## Inspector's Report ABP-317659-23

Whether the (a) demolition of a two-storey extension measuring 92 sq. m. to the rear of dwelling, (b) construction of new two-storey extension measuring 129 sq. m. to the rear of dwelling, (c) demolition of a single storey sunroom measuring 5 sq. m. on the western side elevation, (d) construction of a single storey extension measuring 2 sq. m. on the western side elevation, (e) construction of lean-to roof on the western elevation measuring approx. 6900mm long and 160mm wide and (f) construction of a wooden fence measuring 2m in height along the western boundary in the front garden of the house is or is not development or is or is not exempted development.

10 Burrow Road, Sutton, Dublin 13

CURRENT GROUND FLOOR
PLAN WITH NEW EXTENSION

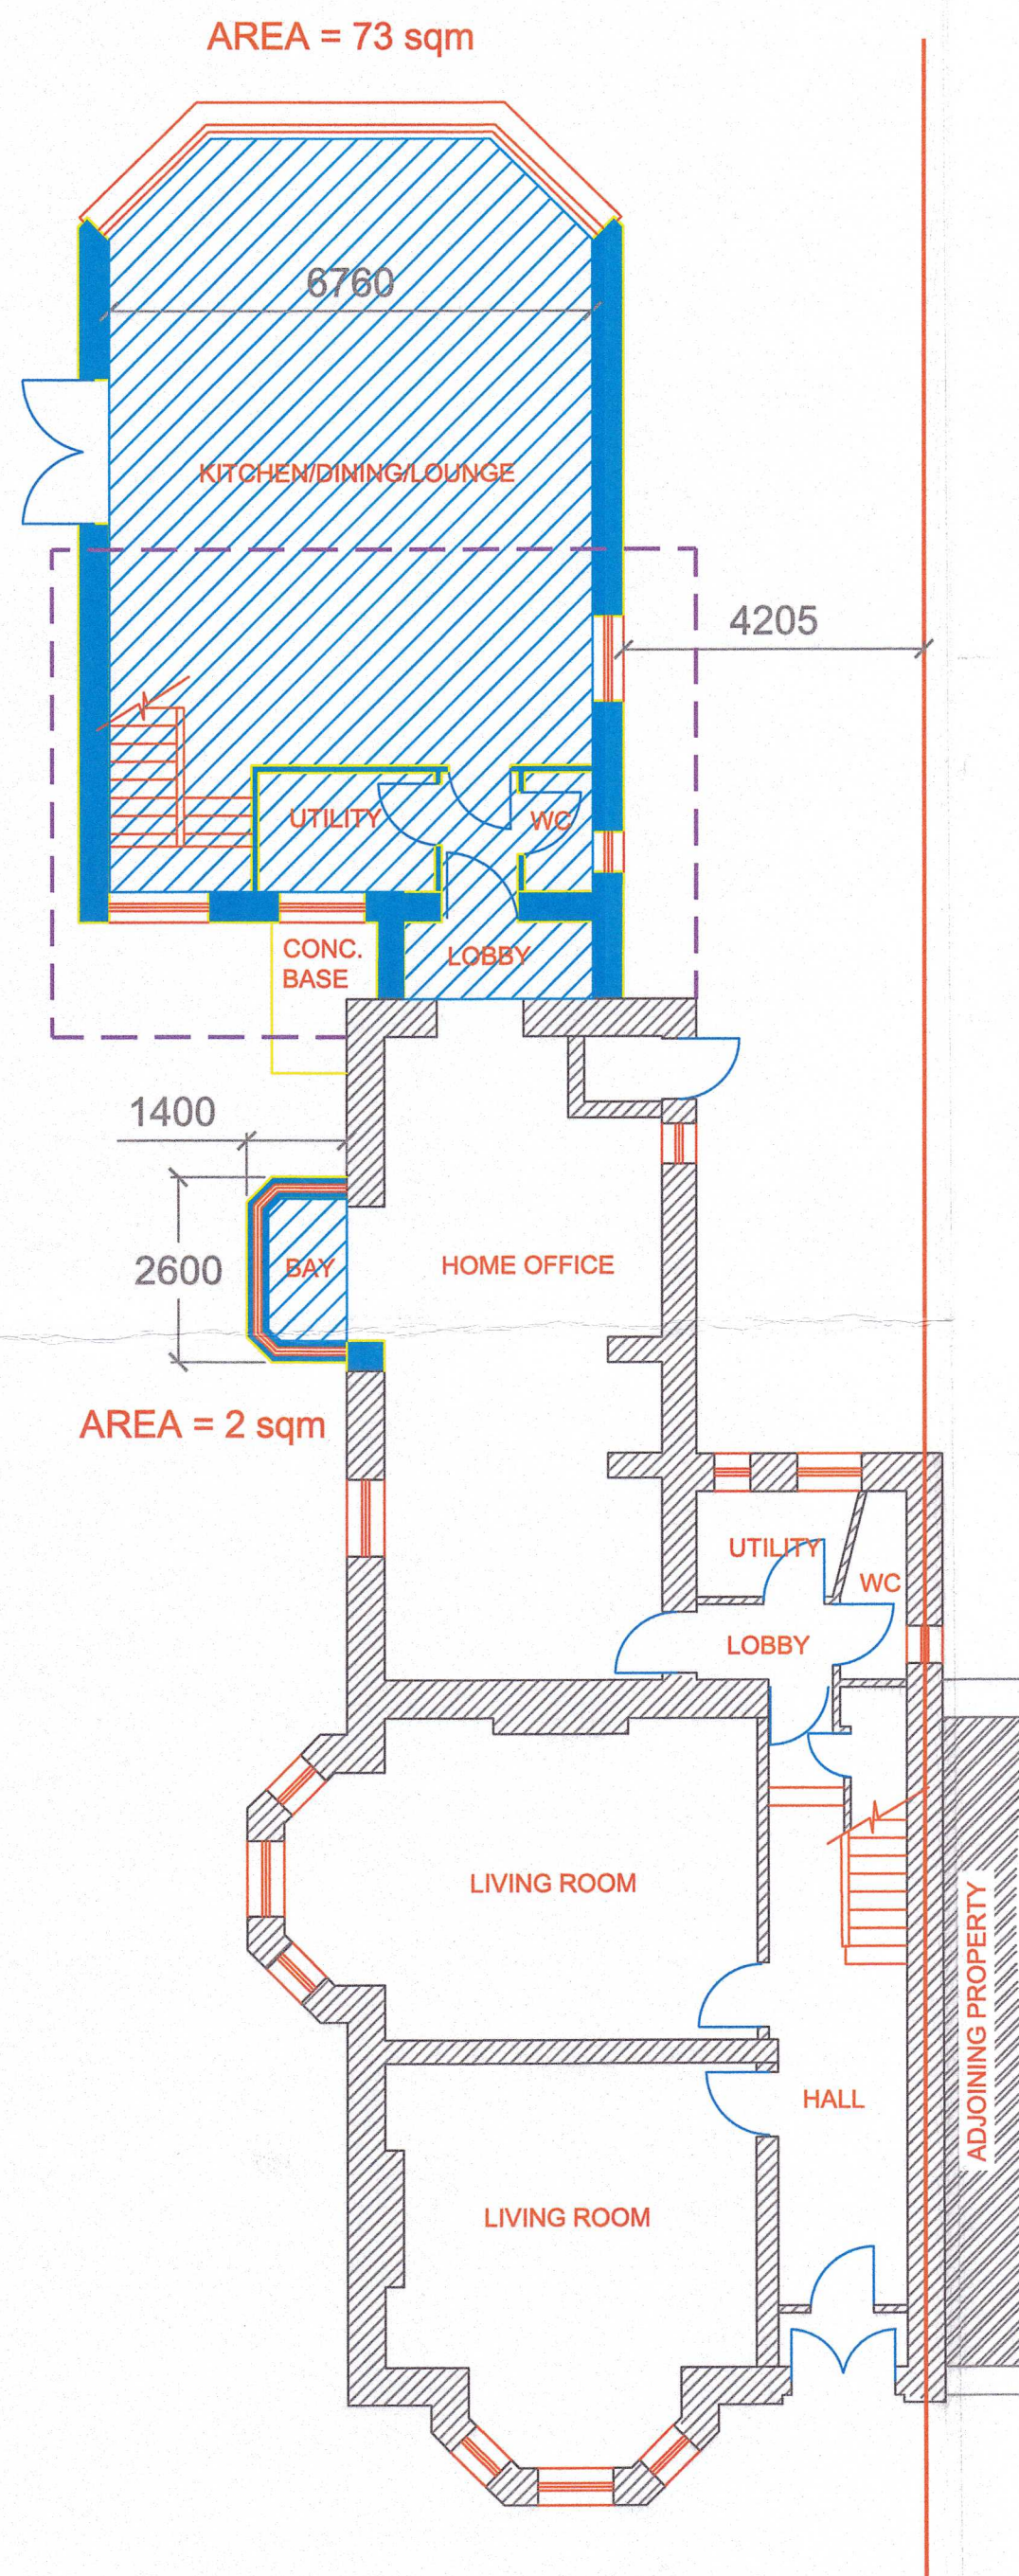
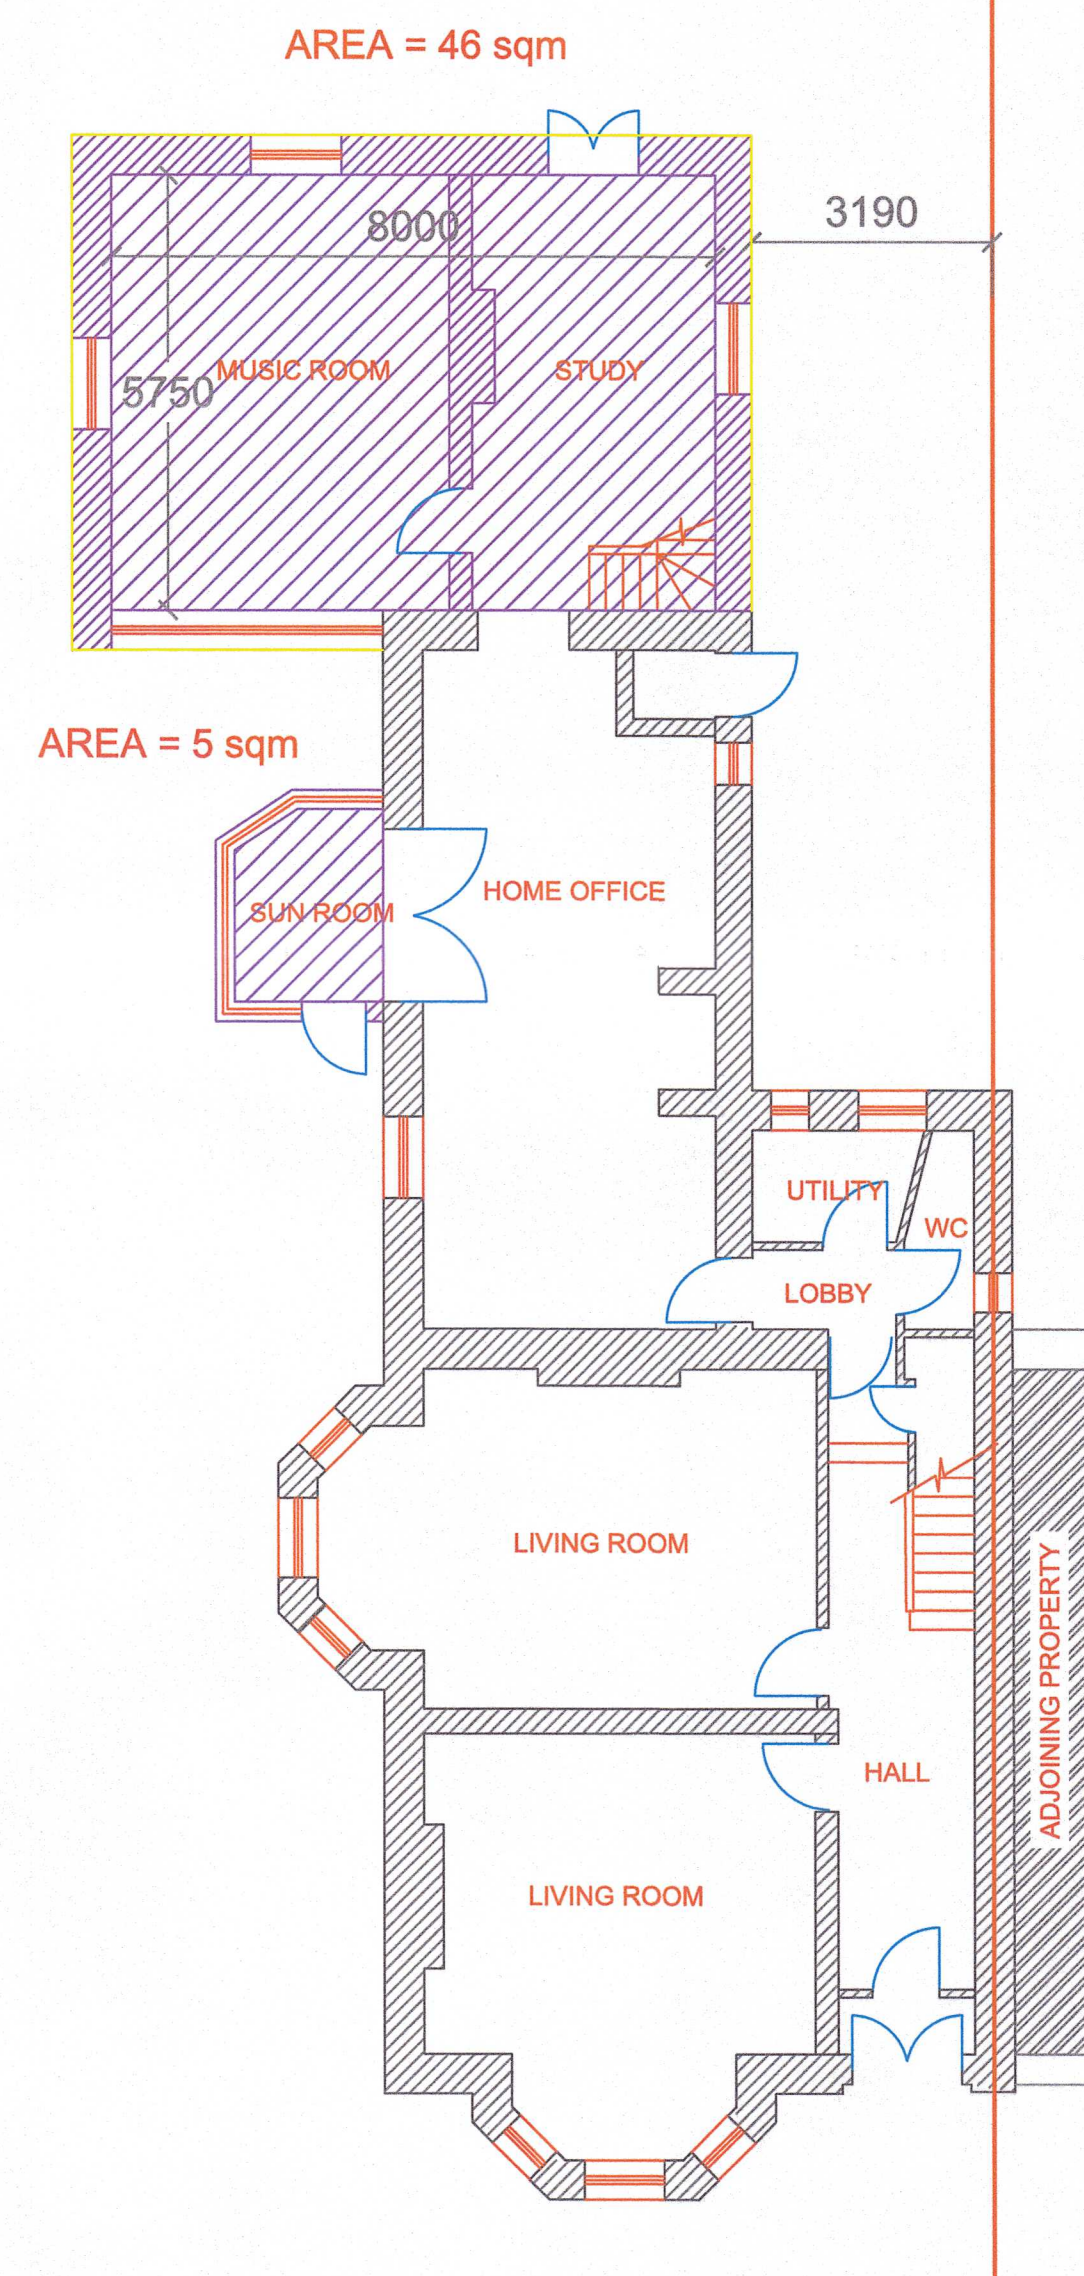
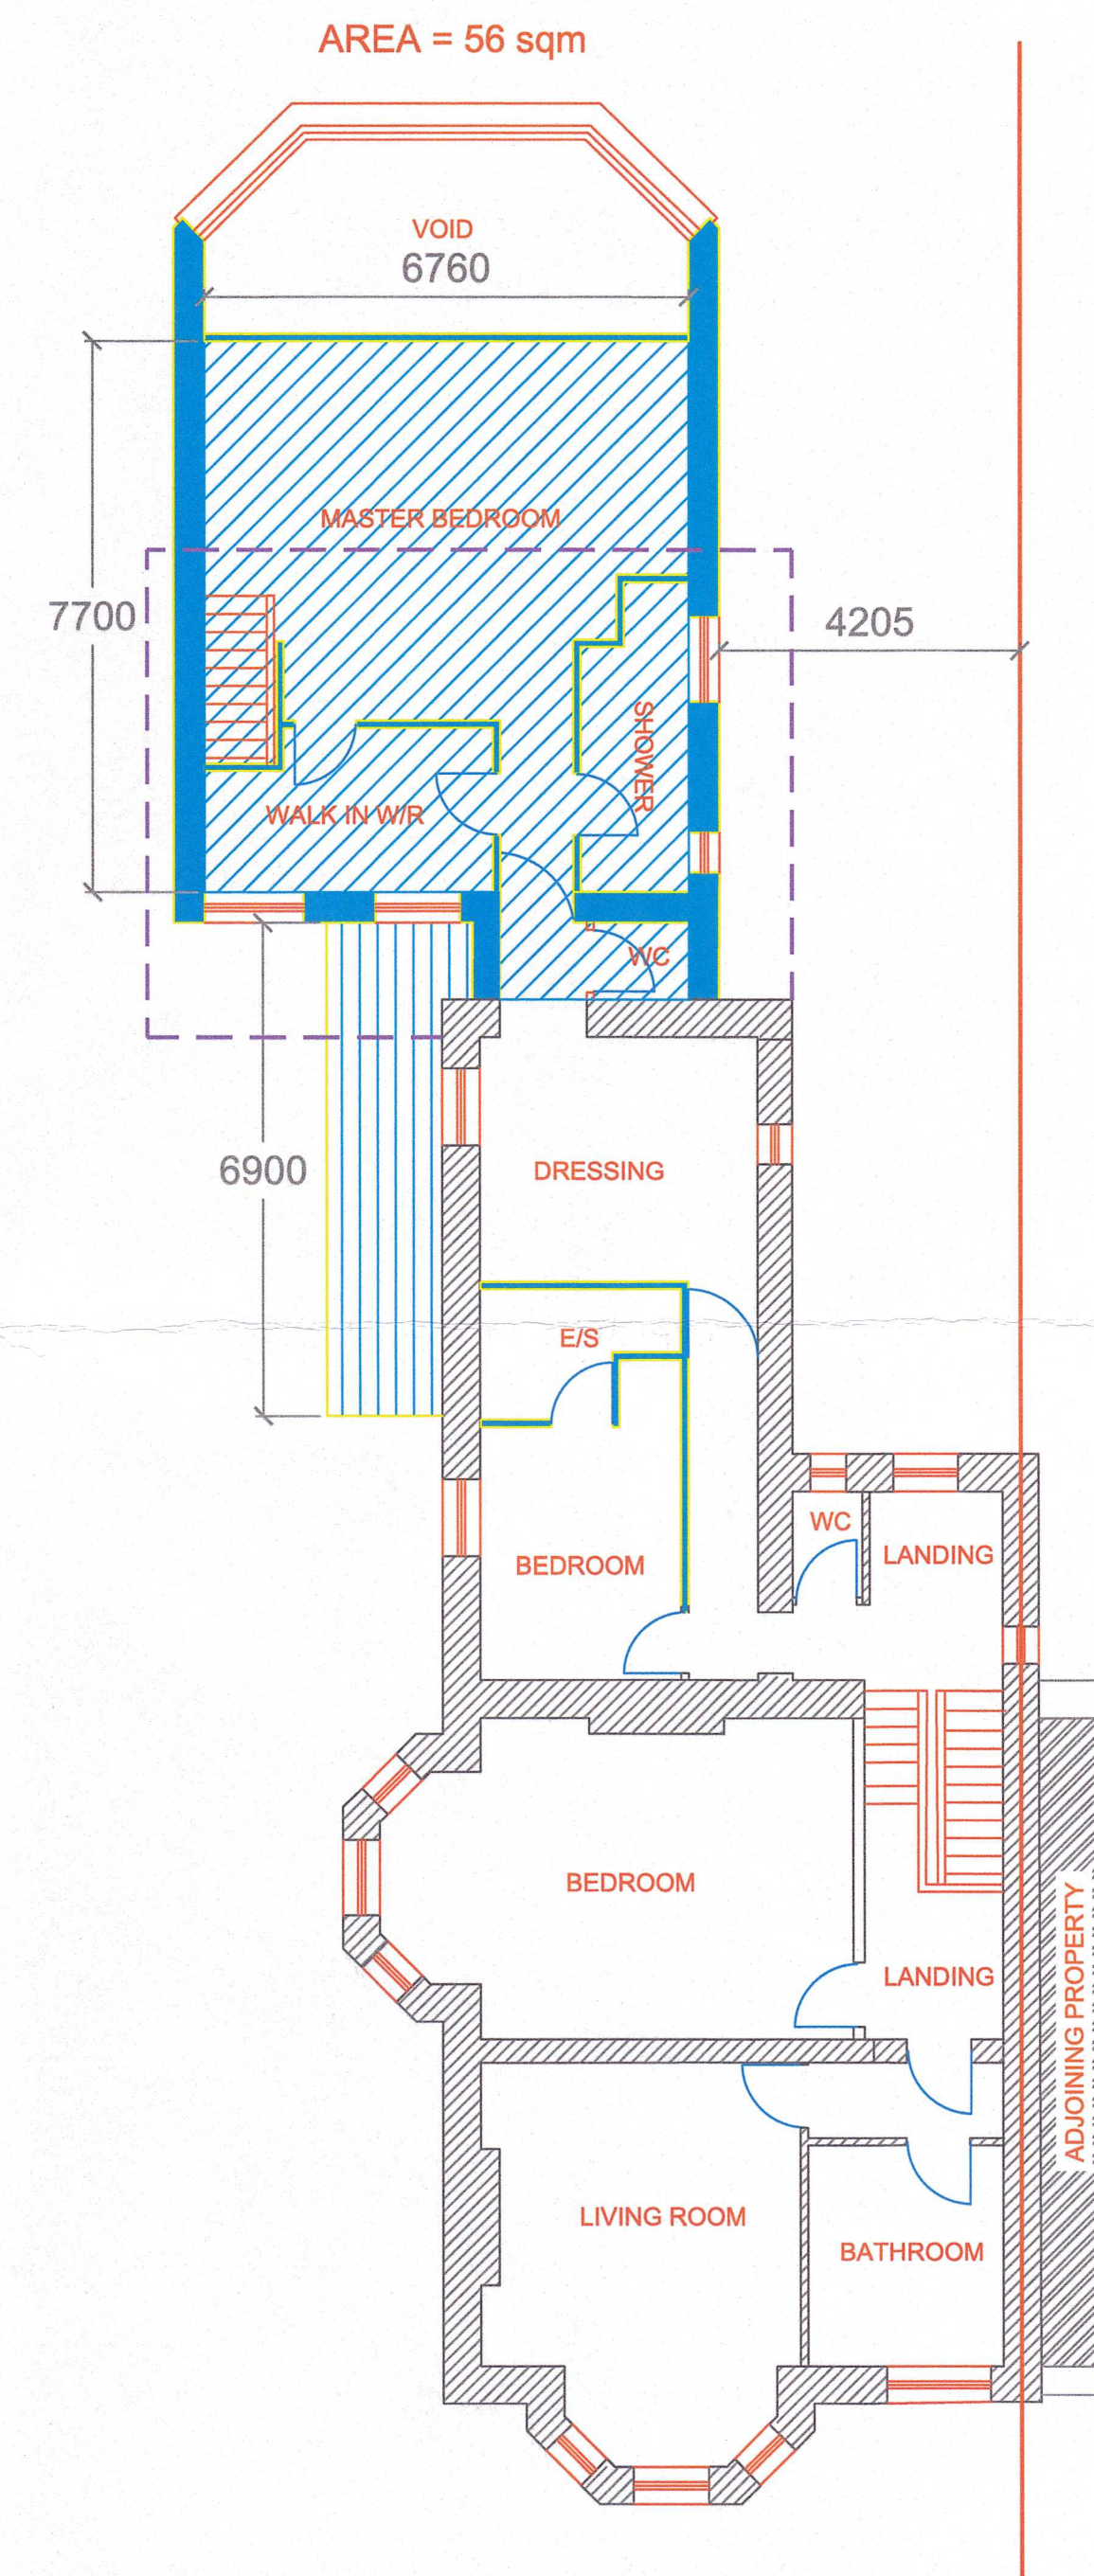
- 8.1.6. Both the pre-existing and existing extensions are shown on plans and elevations submitted by the referrer (FCC). The plans of FCC detail a two-storey extension with a total GFA of 129sqm (73sq.m at ground floor level and 56sq.m first floor level). Mr Farrelly disputes the dimensions as shown on FCC's drawings stating that the new extension extends to 123sqm GFA, (71sqm at ground floor level and 52sq.m at first floor level). Additional plans and elevations were included as part of Mr. Farrelly's Referral Response statement; however, there drawings are not shown to scale. The Board will note that the dimensions (internal room length and width) shown on both

sets of drawings are the same. For example, the dimensions of the first-floor master bedroom are shown on both sets of drawings as 7.7m(l) x 6.760m(w) which equates to a floor area c52sqm. However, this calculation does not include the additional floor area contained within the small link corridor newly constructed between the main dwelling and the master bedroom, which is shown on the drawings to incorporate a WC. The corresponding space at ground floor level is occupied by a 'lobby'. This leads me to believe that the discrepancy in floor area calculations arises from the inclusion or not of the floor area within this 'link' space. However, this view is based solely on my review of the plans submitted, I did not take any internal measurements of the extension and therefore I cannot verify the floor areas. Notwithstanding, I am satisfied that this issue does not need to be resolved for the purposes of this assessment and I am satisfied that the Board can make a determination on the referral questions based on the information available.

- 8.4.7. As detailed on the drawings submitted, the pre-existing two storey extension was positioned behind the rear (northern) building line of the original house (as it appears on the Historic 25-inch map) and projected approximately 4.1m from the dwelling’s western elevation. Therefore, prior to demolition it could be argued that the rear of the house was defined by the northern elevation of the pre-existing extension. However, as previously established, once the pre-existing extension was demolished, it ceased to exist and therefore in my opinion, the rear of house at the time of the construction of the new extension was defined by the northern elevation of the original house (as it appears on the Historic 25-inch map).

8.4.8. As detailed on the drawings submitted, the new two-story extension (the subject of this referral) is partially constructed over the footprint of the pre-existing extension. It is positioned behind the rear (northern) building line of the original house and projects c3.7m to the side, beyond the dwelling's primary western elevation. Since the new extension projects significantly to the side, beyond the side elevation of the original dwelling, the extension cannot, in my opinion, be classified as being 'to the rear of the house'. I therefore consider that the exemption under Class 1 cannot apply in this instance. In support of this position, I refer the Board to referrals RL.2107, RL2506 and RL3115, where the Board determined in all cases, that an extension to the rear of an existing house that projected significantly to the side, beyond the side elevation / gable was not exempted development.

- **Cond's 1 and 2** relate to floor area, both conditions place a restriction on the size of any qualifying extension at 40sqm. The distinction between these two conditions is whether or not the house has been extended previously. In this case, although the house has been extended previously, said extension has been demolished and no longer exists. As such I consider that Cond 1(a) "where a house has not been extended previously" to be the relevant limitation. In support of this position, I refer again to referral RL.2455. The newly constructed extension with a floor area of c123sqm, far exceeds the 40sqm limit set by Cond. 1(a). The floor area of the extension above ground level (+52sqm) also far exceeds the 12sqm limit set by Cond.1(b).

- **Cond. 3** requires a separation distance of not less than 2 metres between any above ground floor extension and any party boundary. I am satisfied that this condition has been complied with.
